Planning Application Ref: Y/49/18/PL

Location: Land East of North End Road, Yapton

Description of works: Development of 10No. residential properties & associated infrastructure. This application is a Departure from the Development plan

Tree Officer / Parks and Greenspace Team

Tree protection plan

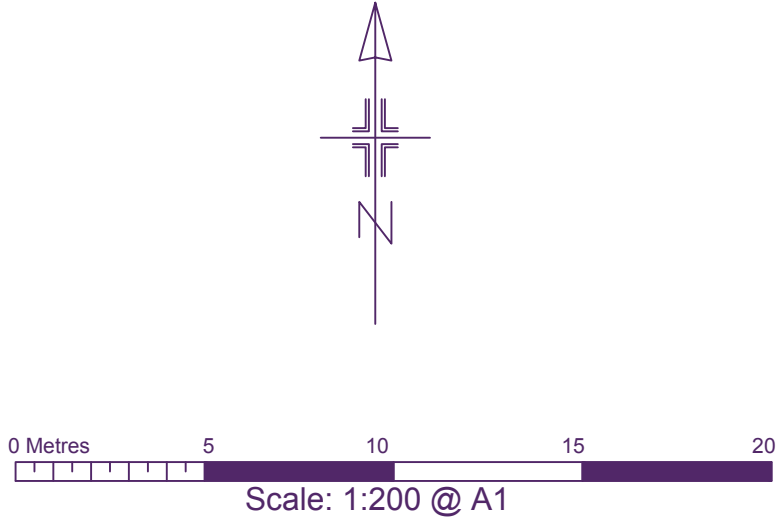
- The Tree Survey data is comprehensive and accords with the requirements of BS5837:2012.
- Those trees within the site are almost exclusively managed as hedgerow, of variable quality and confined to the perimeter. While the roadside section of hedgerow (H1) has screening value it is not of sufficient value so as to be a complicating factor. That said, it is reassuring to see that the vast majority of H1 will be retained and afforded adequate group protection. This will undoubtedly add some value to the development.

- H2 is of low value although the removal of such a long group of established trees of any kind should be mitigated by the implementation of a comprehensive replacement tree planting scheme.

- So far as I am aware, the Parks and Greenspace Team have not had sight of a detailed Landscape Plan. There would appear to be ample opportunity to implement an ambitious replacement tree/shrub planting programme, utilising some species that will have longevity and thereby provide both landscape and ornamental value for this development and the surrounding area.

- I recommend **APPROVAL** for this application subject to the following condition being applied:
 - All activity at the site is to be carried out in strict accordance with: - **Arboricultural Appraisal and Method Statement, Ref: 18062-AALet-AN, dated 28th February 2018 (Barrell Tree Consultancy).**
 - The applicant must retain the services of their project arboriculturist to ensure the protective fencing as described (SGN2) is correctly installed as per the **Tree Protection Plan, ref. 18062-BT1** and most importantly before the site is occupied or any machinery is introduced to the site or demolition work or construction work or alterations to existing ground levels takes place.
